May 15, 2025

**RE: Immer (RU-25-0001) Reasonable Use Exception – Request for Information & Project on Hold**

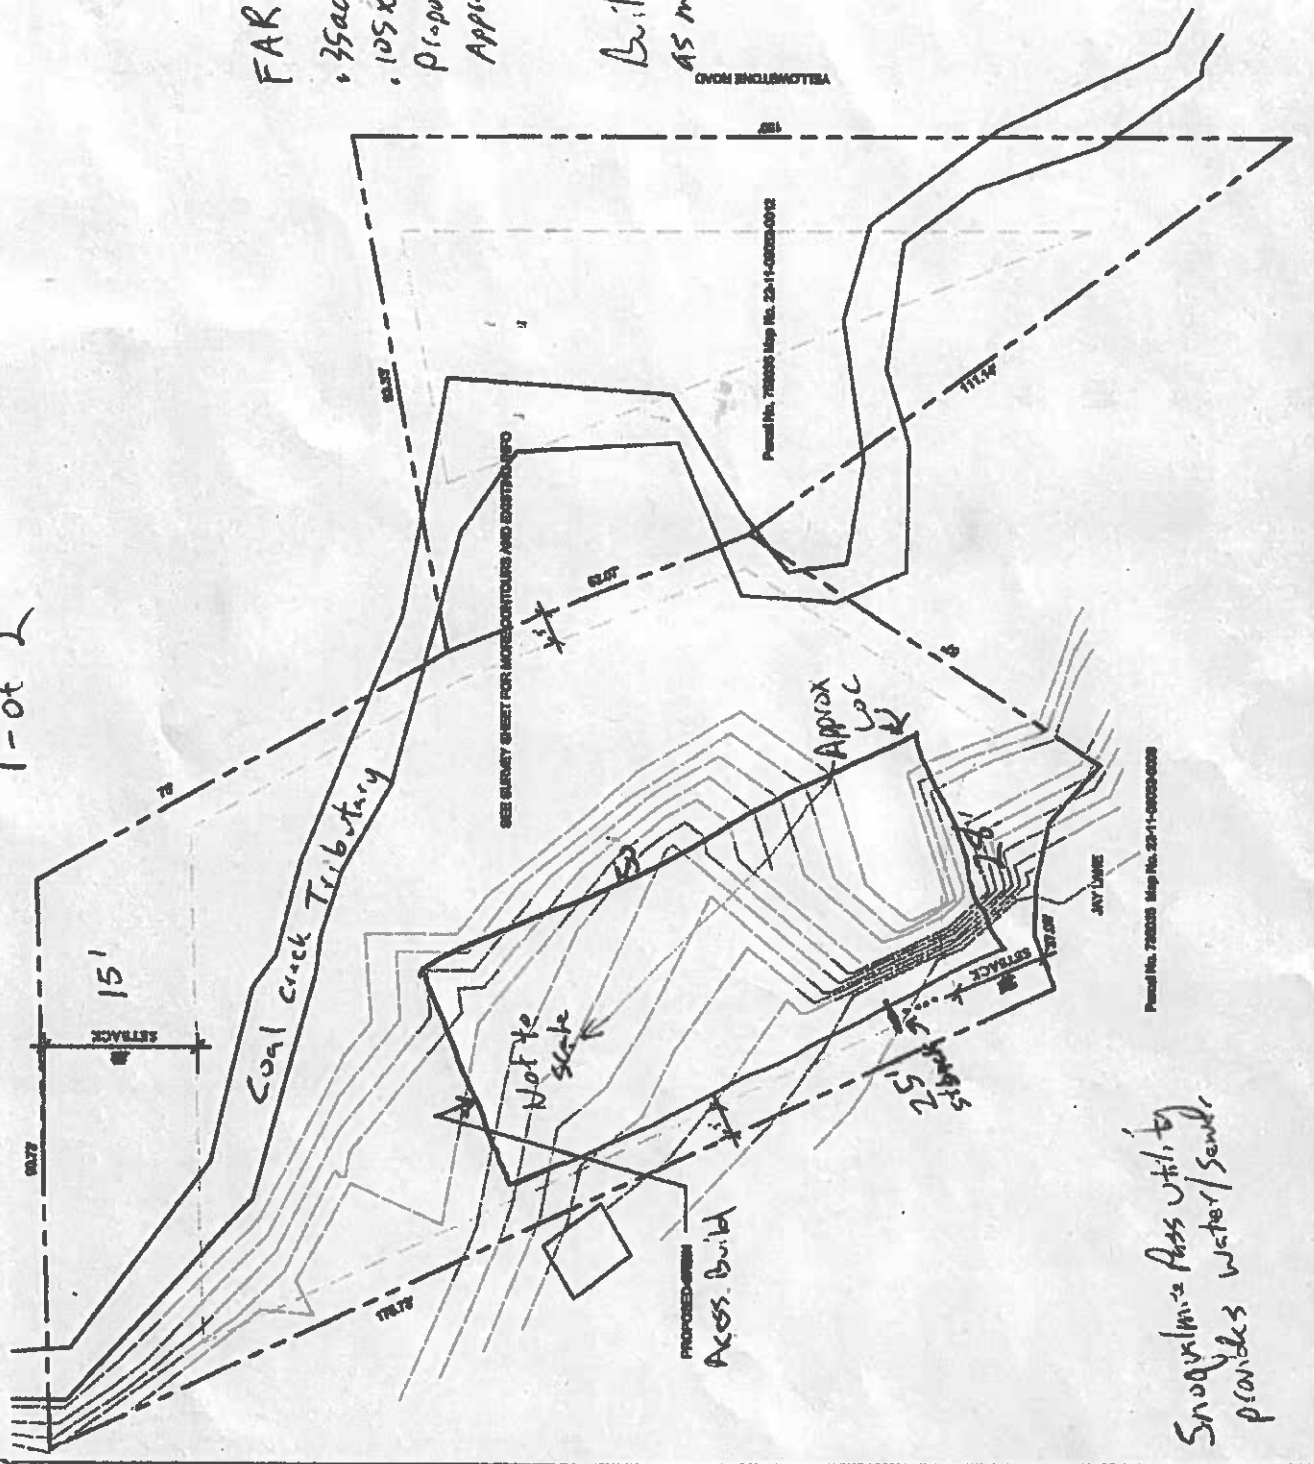
1. An updated site plan that shows a clearer picture of your proposed development. On this site plan, please include labeled topographic lines, the size of the building, the location of the building from the lot lines, the stream, the stream buffer, the wetland at the back of your parcel, the wetland buffers and the current setbacks for this zone (Front: 25', Side: 5', Rear: 15'). It may be helpful to locate on the site plan the large tree that you pointed out that would be on the northeast corner of the proposed building. Please provide this site plan to scale. We need to know where the footprint of the proposed building will be on the parcel in relation to the stream and topography. An accurate & detailed site plan would go along way in understanding your proposal and helping us navigate the best path forward for you. It will also help us determine if moving the building into the setback would be enough to allow a 25' x 50' building or if a smaller building will be needed along with moving it into the setback.

2. The hammer head turnaround needs to be shown on your site plan. It is our understanding that a hammer head turnaround for fire apparatus is being discussed with the county engineer. This hammer head design and location on this small street/turnaround adds to the complexity of this area and may impact your property lines and setbacks. Please include the hammer head turnaround and its location on your site plan

so we have an accurate representation of the proposed development and how the road/joint use driveway improvements will impact your parcel. If the hammer head turnaround extends into your parcel and into your setback, this will reduce the setback available for the placement of the building. In this scenario, the building could not be moved as far forward toward Jay Way as discussed on Monday, which will impact the amount of trees / habitat removed within the stream buffer.

3. Additionally, we'd like to ask you to have the hammer head staked out to show the location and extent of impact the hammer head will have on the parcels at the end of Jay Way. Please stake out the proposed location and size of the proposed building. Given the limited amount of space at the end of Jay Way, it is likely that the road/driveway upgrades will affect any development on the parcels on Jay Way. Jamey Ayling and I will do another site visit so we can see the staked-out areas and how they interface with the topography & parcel.

4. Given the unique nature of this parcel and the amount of fill/excavation required to build, a SEPA checklist may be required for a more thorough environmental review. Please provide anticipated fill/excavation numbers for the accessory building. Your engineer can run these numbers for you.
